DE-2025/82/D

SUBMISSION TO EXHIBITED DOCUMENTS

Development	Smith Street Modification 4 - Alterations and Additions (SSD-67895459-Mod-4) - Request to provide advice on the Modification Application and Report
Location	Lot 201 DP 1313965 120 Street WOLLONGONG NSW 2500

1 SECTION A
 Scale: 1 : 200

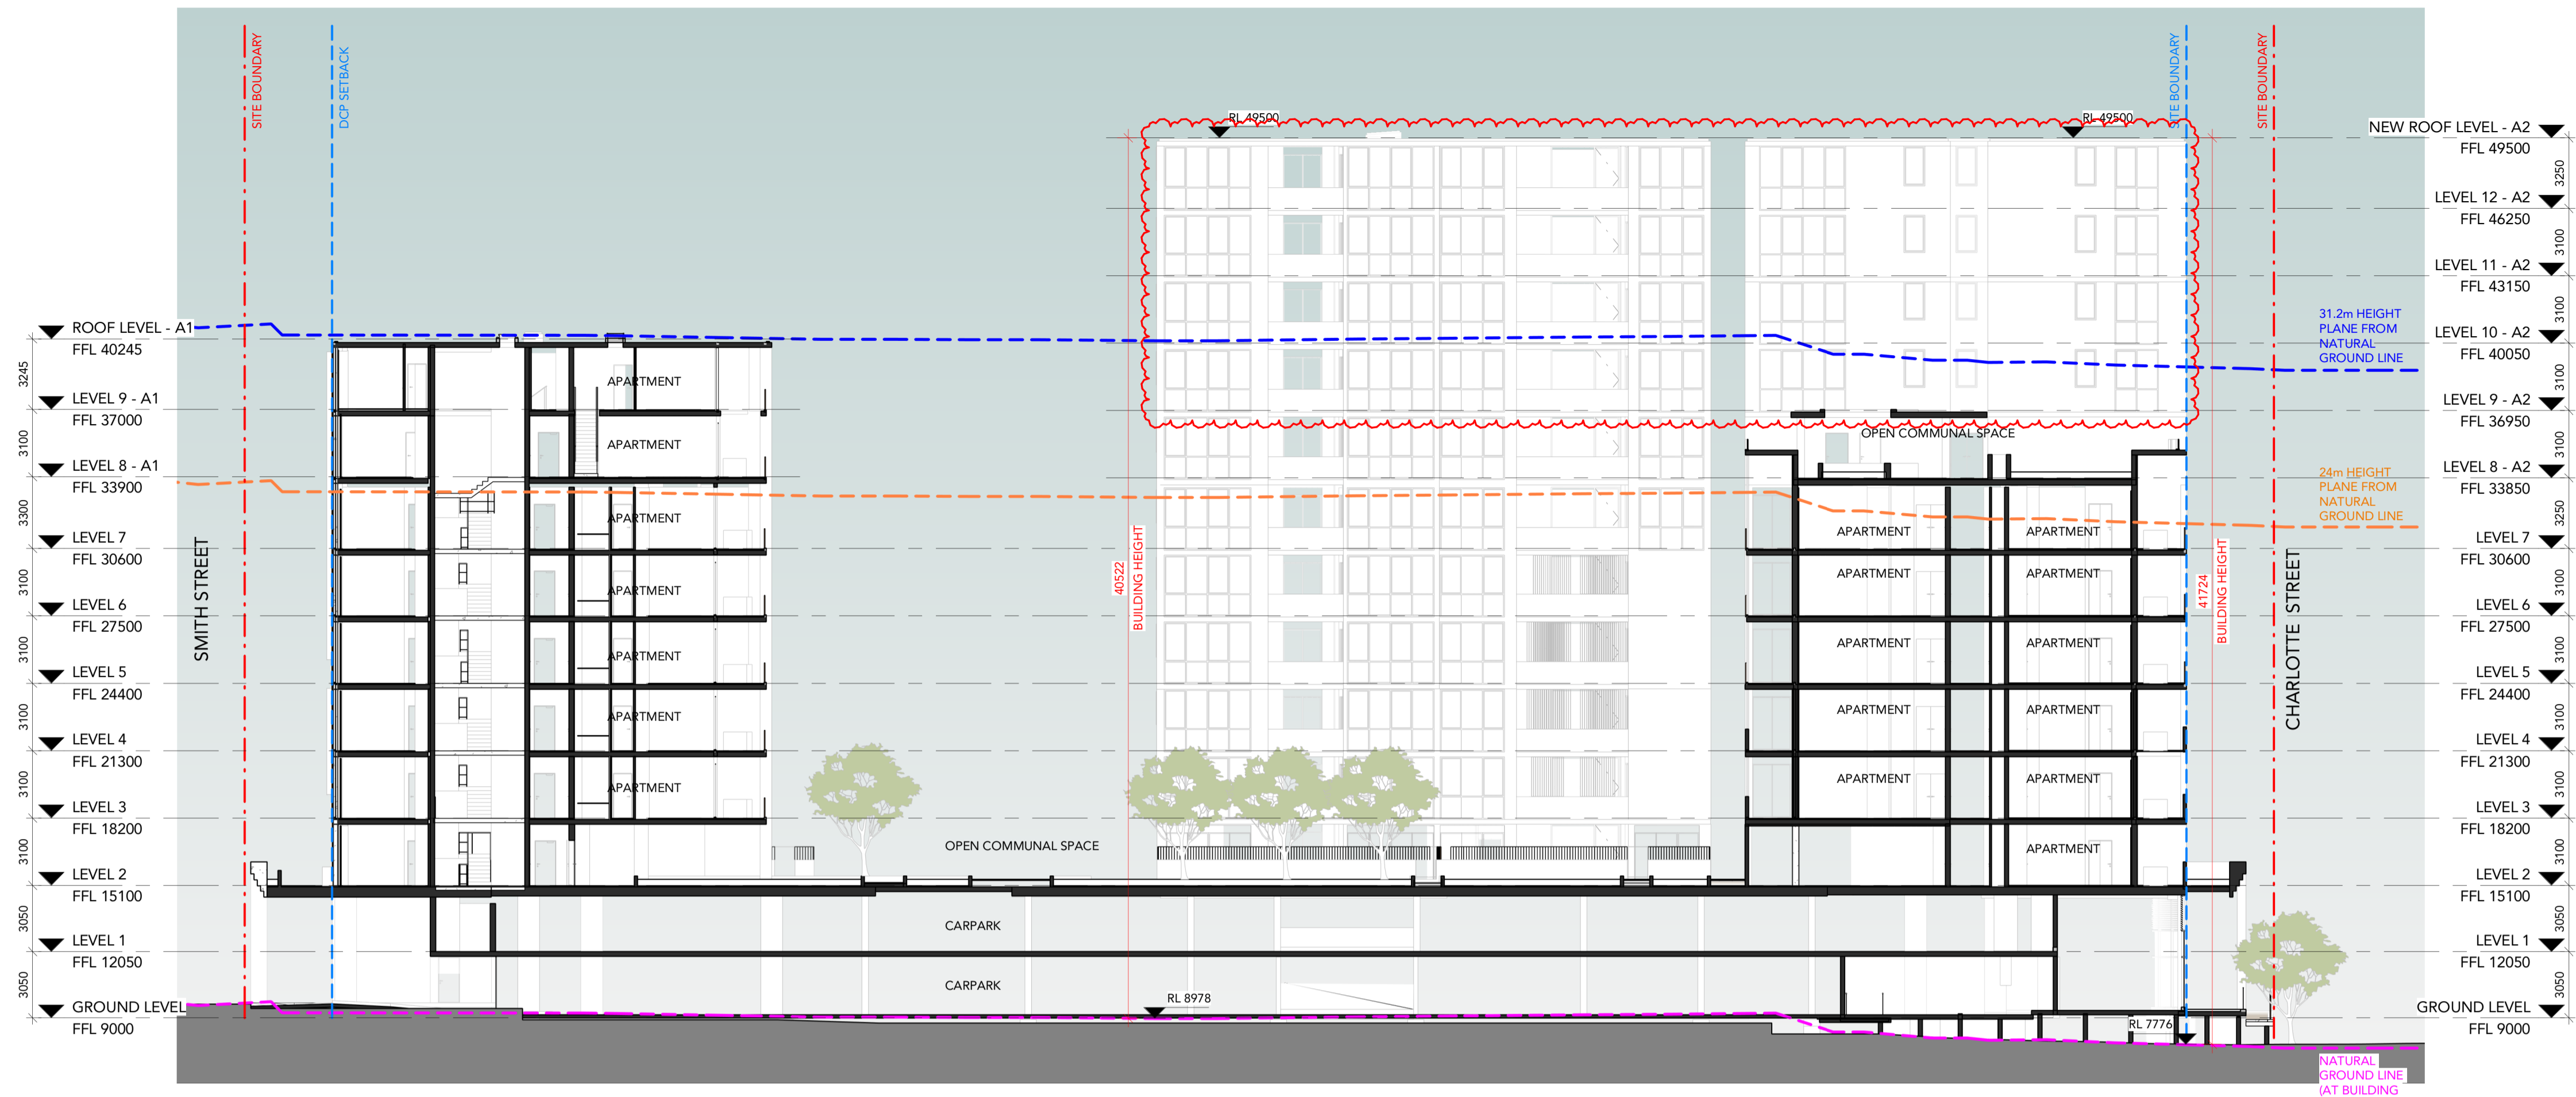
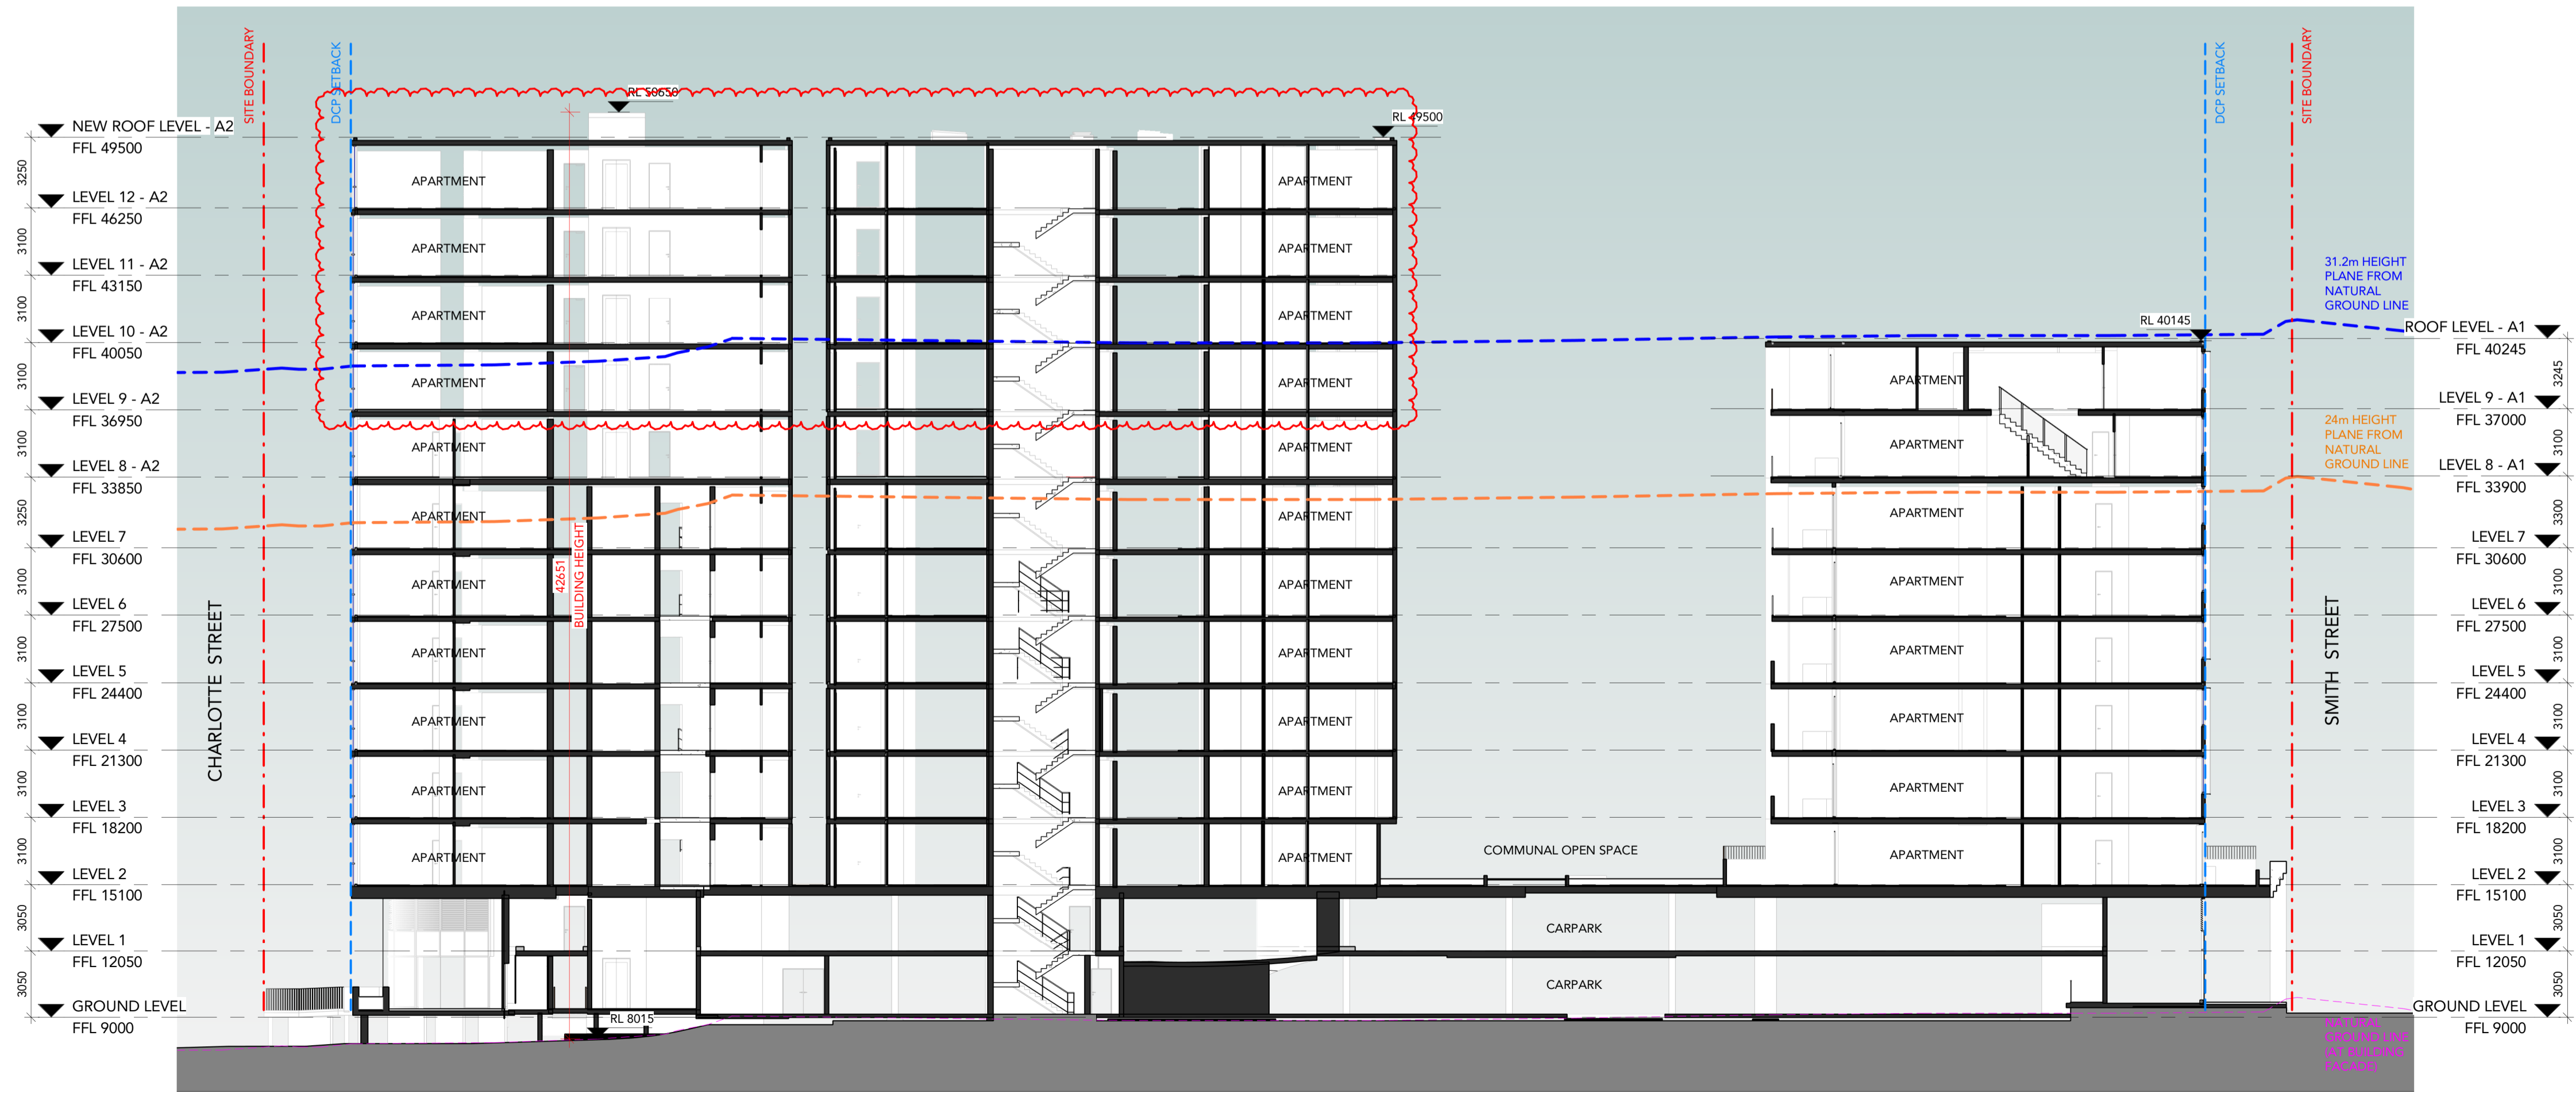
3. The proposed modification would result in Building 2 having a building height of 41.655m. This exceeds the maximum 24m height permitted in Wollongong Local Environmental Plan 2009 and 24m in Council’s exhibited Draft Flinders Street Urban Design Framework (Draft UDF). It also exceeds the maximum 30% affordable housing height bonus provided under State Environmental Planning Policy (Housing) 2021, which limits height to 31.2m.
4. Council does not consider the applicant has adequately justified contravening the permitted height standards. The justification on pages 33 and 35 of the Colliers report does not demonstrate that

6. It should also be noted that providing the uplift on the northern tower would result in additional overshadowing to the Building 1 (and in turn possible reduced amenity and solar non-compliance for units within the Building 1).

Title: **GROUND FLOOR PLAN**

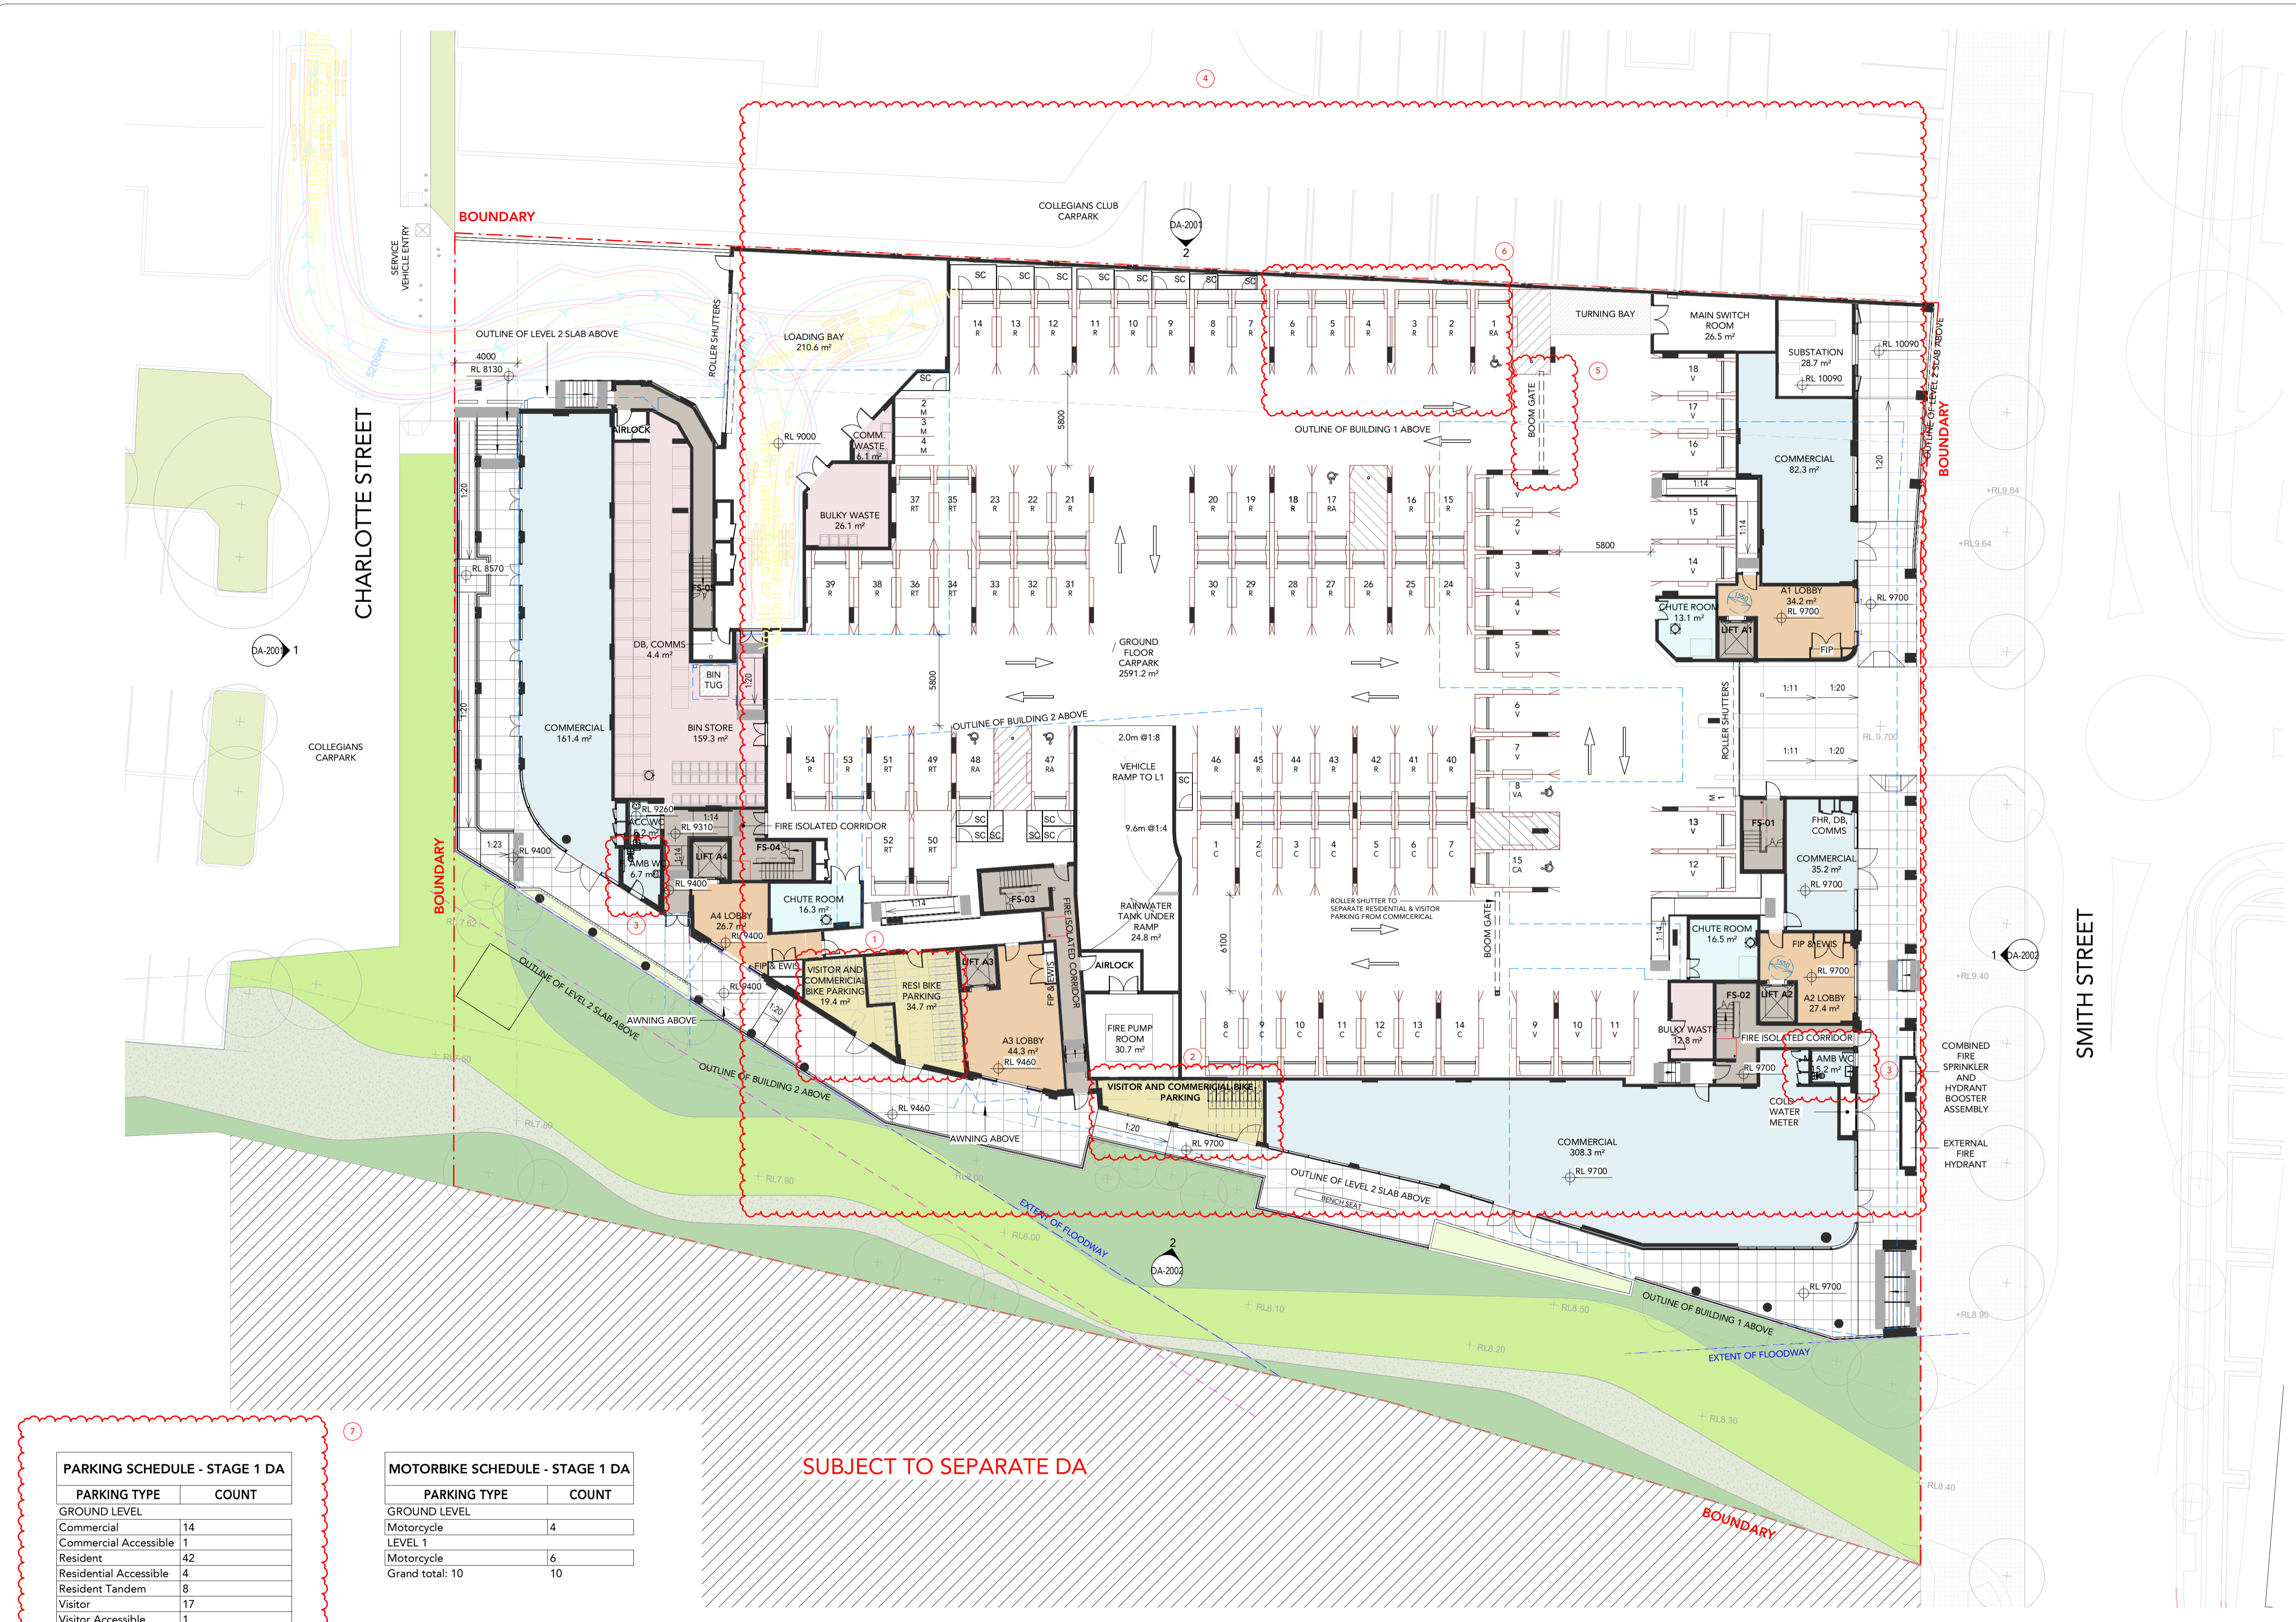
14. The development plans still show the offset 'left in left out' intersection, which is not supported.
15. An offset intersection would result in traffic impacts and vehicle friction in close proximity due to the nearby location of the Young Street intersection, as well as turning impacts elsewhere on the network as drivers re-orientate themselves as a result of any 'left in left out' restrictions. It should also be noted that physical restrictions such as a median or traffic island would be required to reinforce any proposed 'left in left out' restrictions which would constitute a trip hazard/barrier for pedestrians moving around in the local area (a safety and amenity issue), which would not be needed in lightly-trafficked periods of the day or late at night.

21. Council's waste contractor, Remondis, has recently updated the vehicle specifications for vehicles that will enter multi dwelling developments to collect waste. The applicant must confirm that the specifications below have been used in the waste collection swept path assessment to ensure that the loading dock is sized appropriately. If not, there could be operational issues resulting from the collection of waste. Council's waste contractor will not enter a private site if manoeuvring is restricted and on street collection will not be accepted by Council or its contractor.
